24 March 2026
Edwina Ross
Senior Planning Officer
Edwina.ross@dpie.nsw.gov.au

RE: Objection to Development Application SSD-93020230 at 40-48 Muston St, Mosman

Key points of objection to Development Application SSD-93020230 at 40-48 Redan Street, Mosman

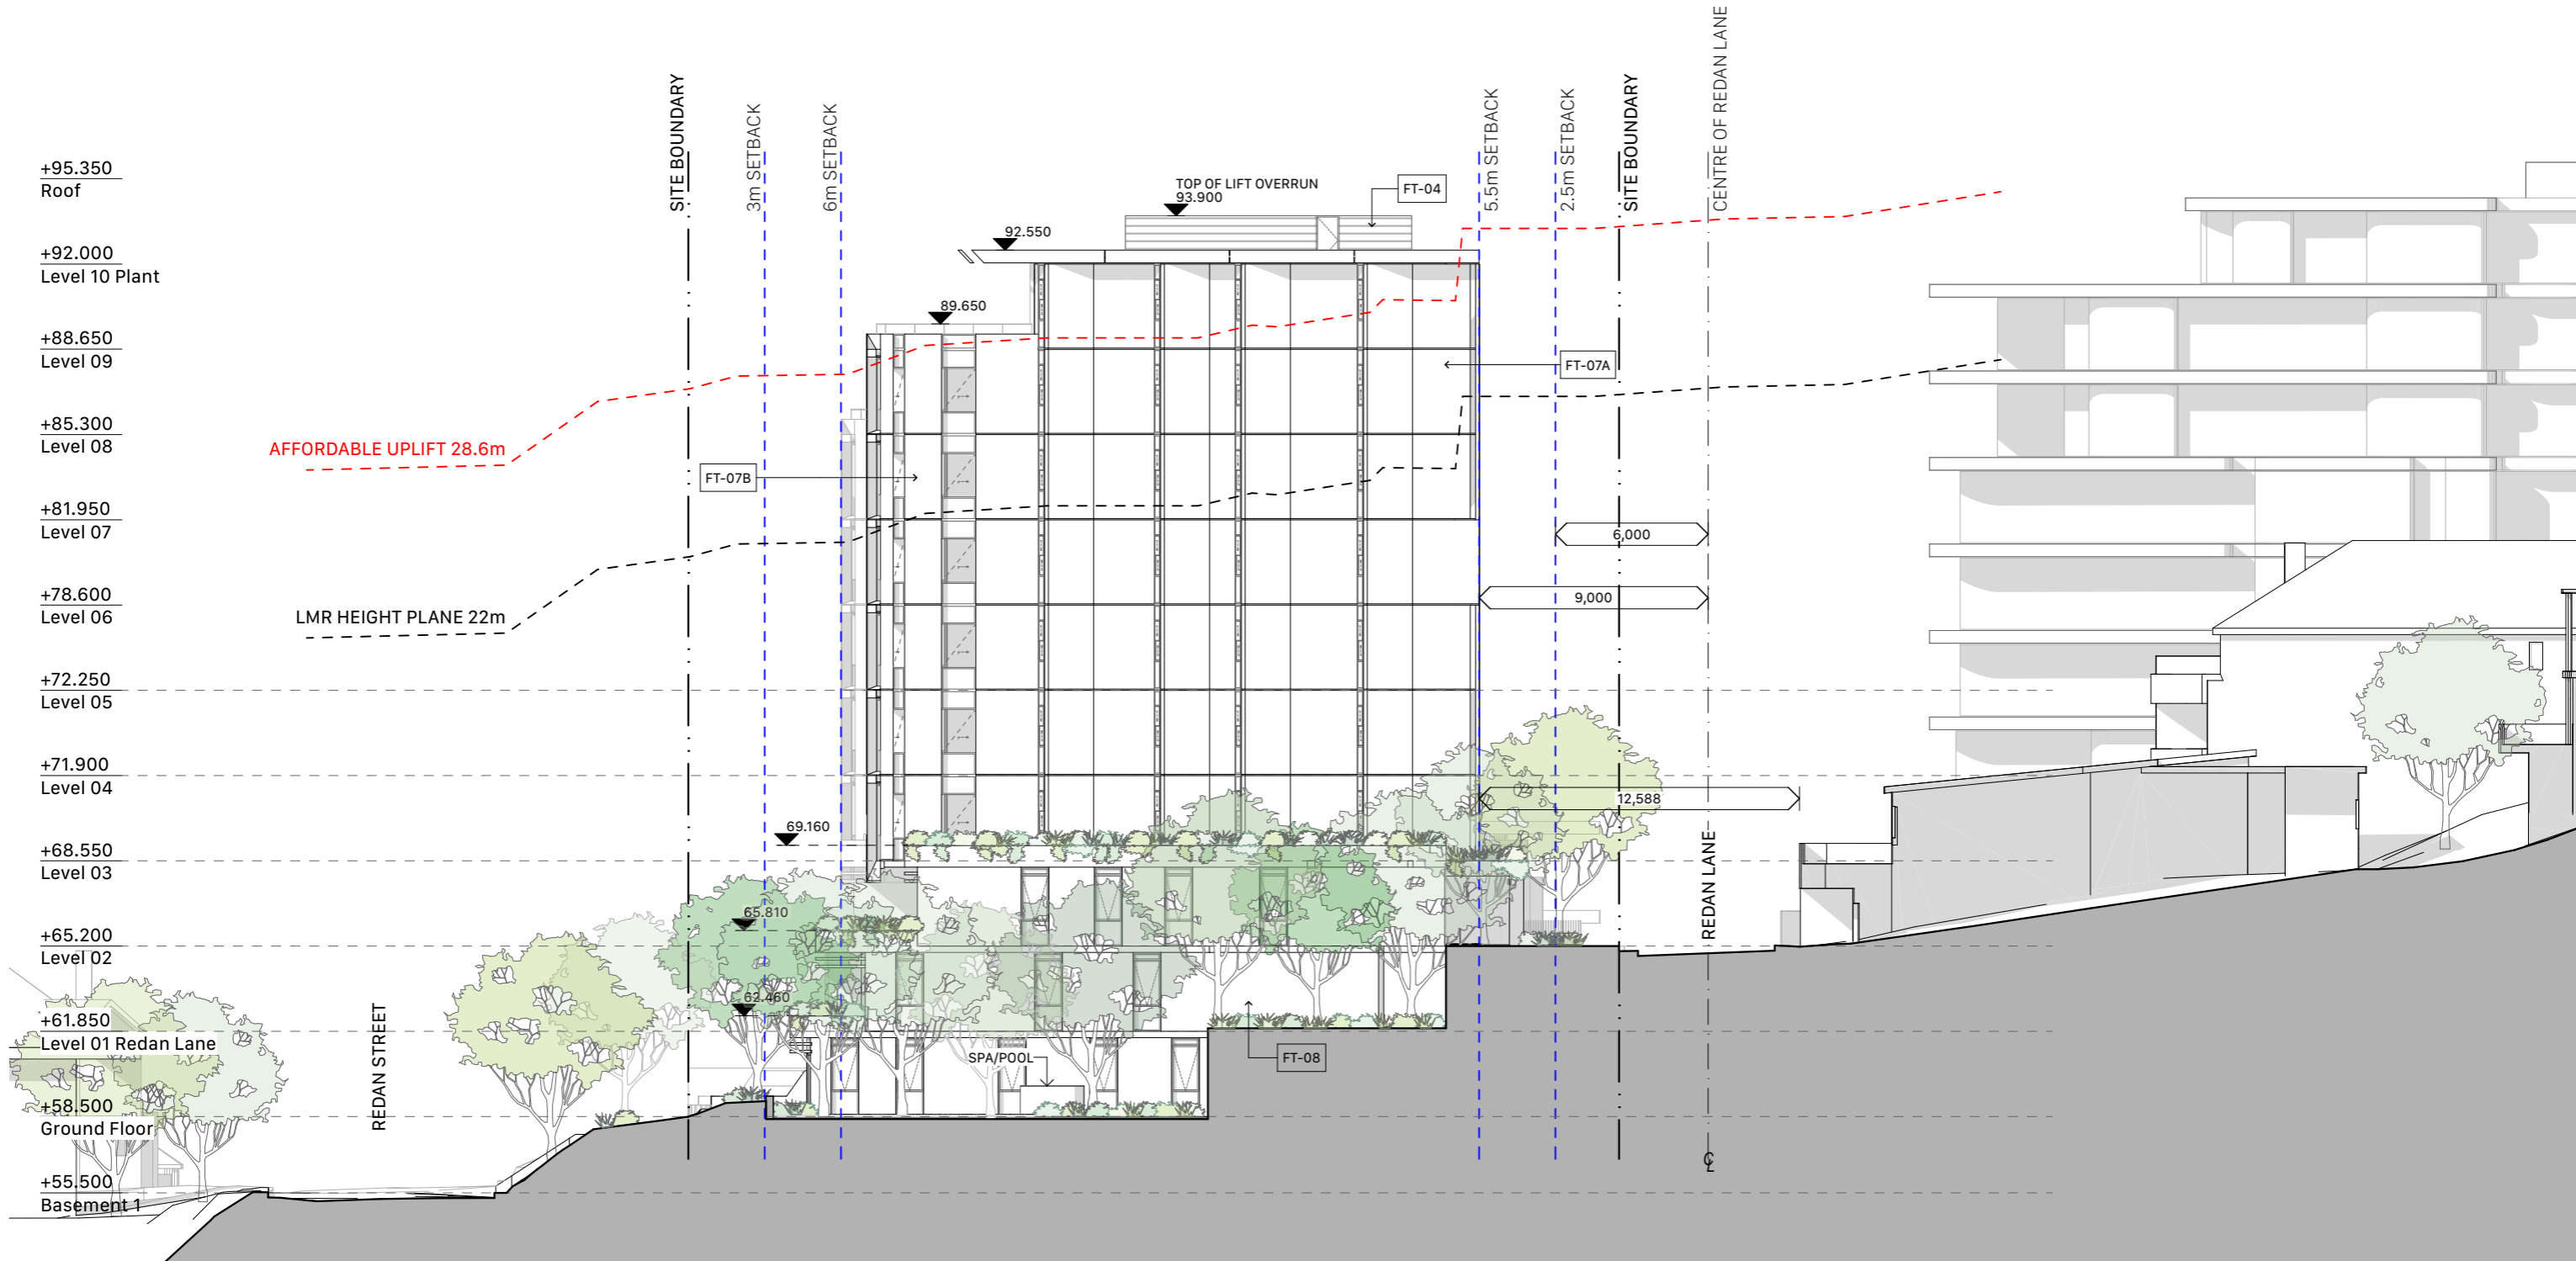
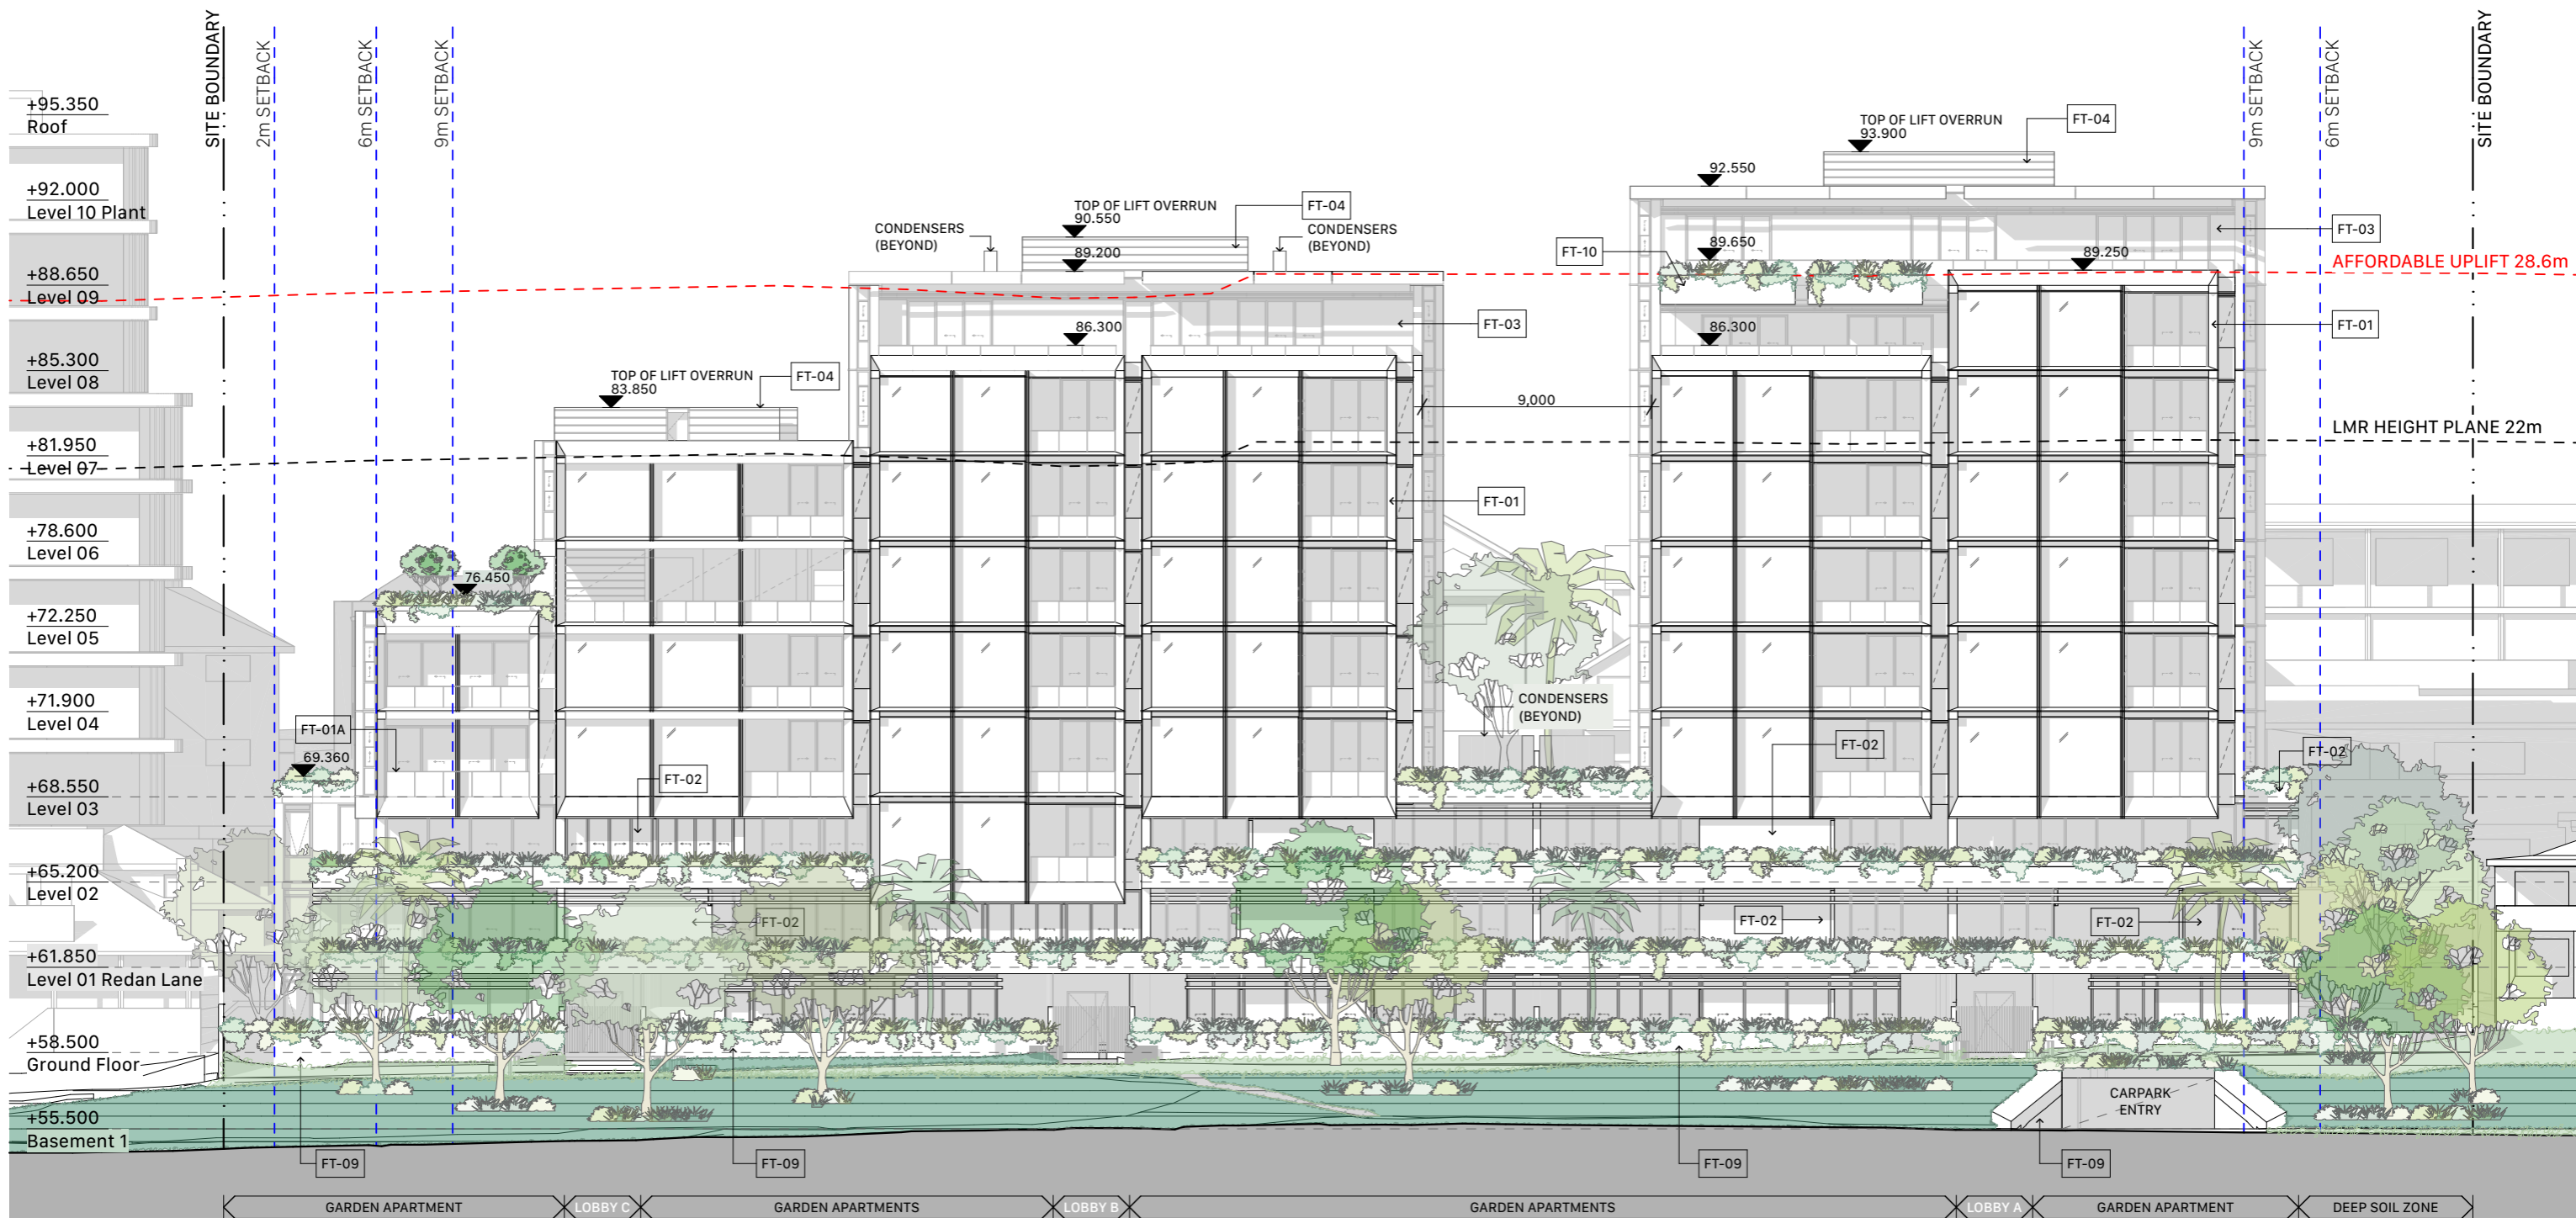
The proposed development exceeds the applicable height limits. While the building steps down towards the heritage-listed property at 36-38 Redan Street, the transfer of bulk to the northern portion of the site is inappropriate and unjustifiable. If the application is not refused outright, the northern elevation must be significantly reduced in height while maintaining the 9-metre setback.

40-48 Redan Street, Mosman 40-48 Redan Street Mosman NSW 2088	Elevation West - Redan Lane Elevations	Rev Date Description By Chk	Scale	Code	Sheet	Rev	0 2.5 5 10m
		B 27/2/2026 SSD Submission Lodgment IS	1:250 @ A3	TPRS	3003	B

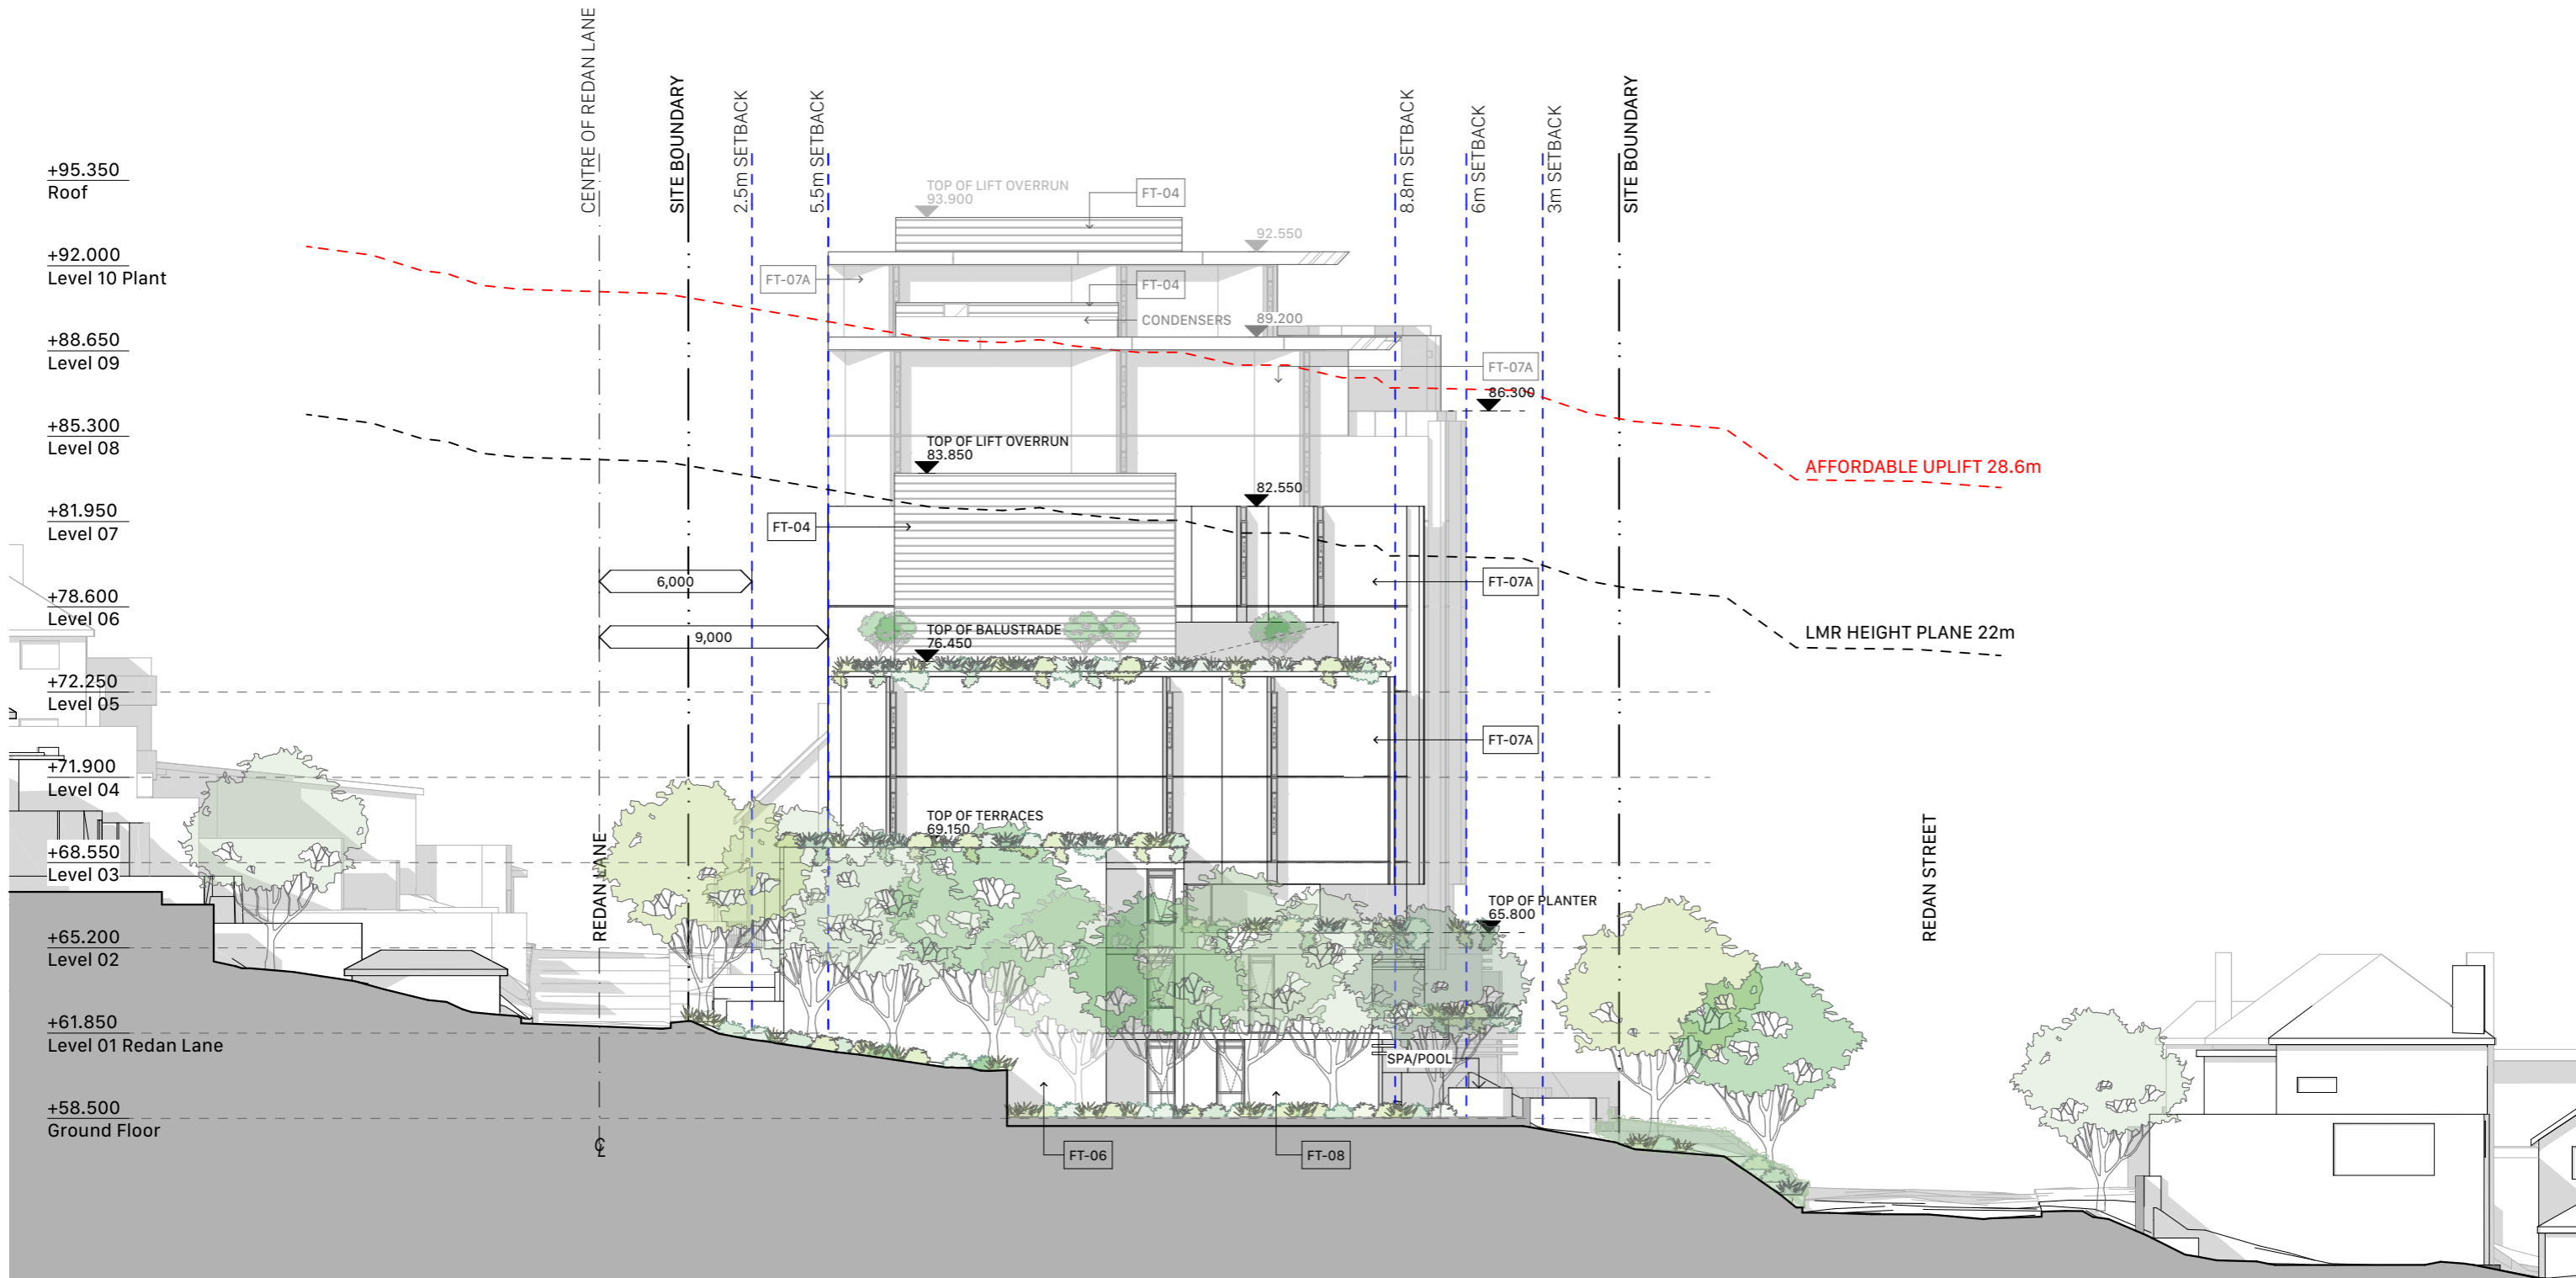
- ✚ Military Road is incorrectly labelled as Redan Lane (see pages 2–3 of the architectural drawings).
- ✚ The width of Redan Lane has been inaccurately depicted. In the renders, it appears as a wide two-way street, whereas in reality it is a narrow laneway.
- ✚ Setbacks from Redan Lane have been incorrectly measured from the centreline of the road rather than from the site boundary. This is a fundamental error and misrepresents the true bulk and scale of the proposal.
